# DEVELOPMENT HEARING OFFICER

**PR-2021-005714**

**SD-2023-00165 – PRELIMINARY/FINAL PLAT**  
**SKETCH PLAT 7-14-21 (DRB) IDO - 2022**

**REQUEST:** LOT CONSOLIDATION: 8 LOTS INTO 1 LOT

PLAT
OF
LOTS 1-A
MONKBRIDGE ADDITION
PROJECTED SECTION 5 T10N, R3E, N.M.P.M.
WITHIN THE TOWN OF ALBUQUERQUE GRANT
ALBUQUERQUE, BERNALILLO COUNTY, NEW MEXICO
JUNE 2021

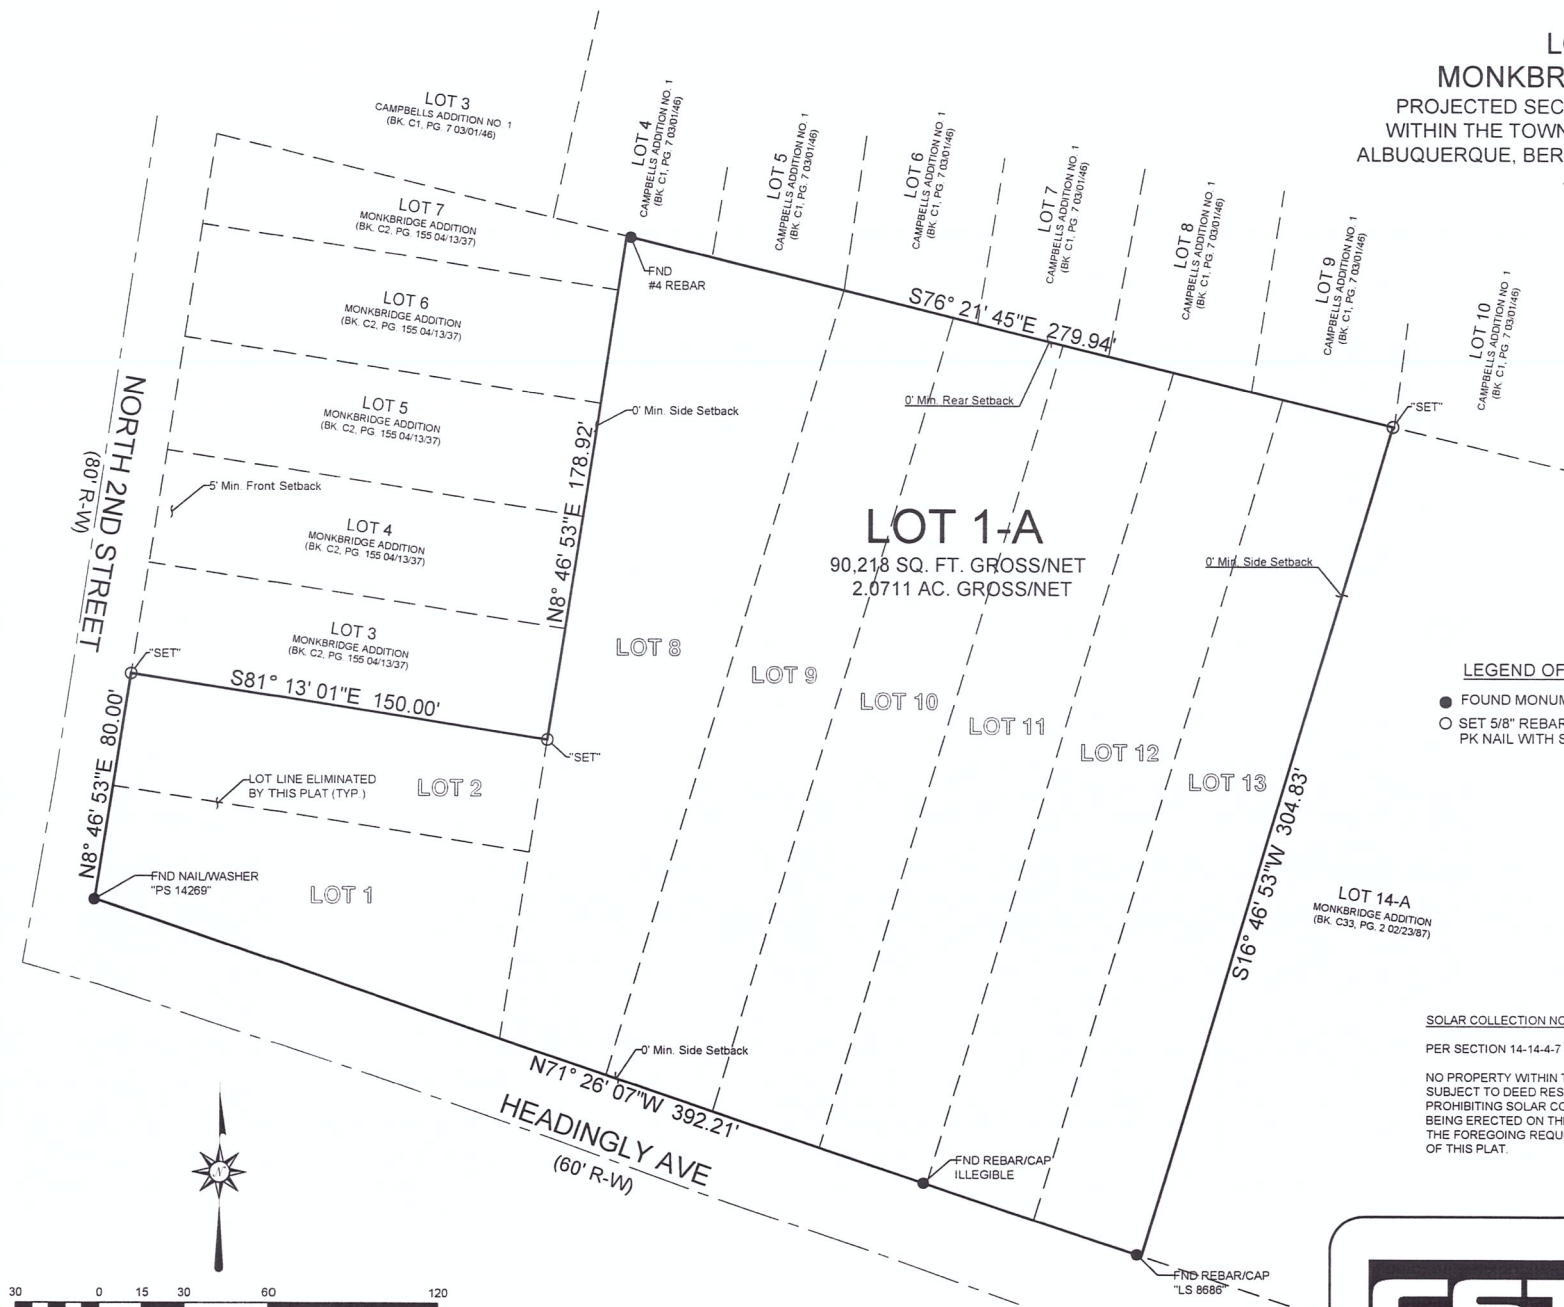
1. Previous comments still apply – no new submittal showing the note has been added.
  - a. Preliminary plat:
    - i. Add the following note to the plat.
      1. “Existing public water and/or sanitary sewer infrastructure may not be constructed or sized to adequately serve potential future development. Improvement or upsizing of existing public infrastructure may be required as a condition of future development approval.”
    - ii. No issues with the proposed lot consolidation.
      1. Availability Letter 230411 has been issued and identifies the conditions for service for the proposed site plan. Fire flow cannot be met with existing conditions and line upsizing is required. Construction or infrastructure list with financial guarantee to install new fire hydrant and installation of new 8” main for the proposed development will be required.
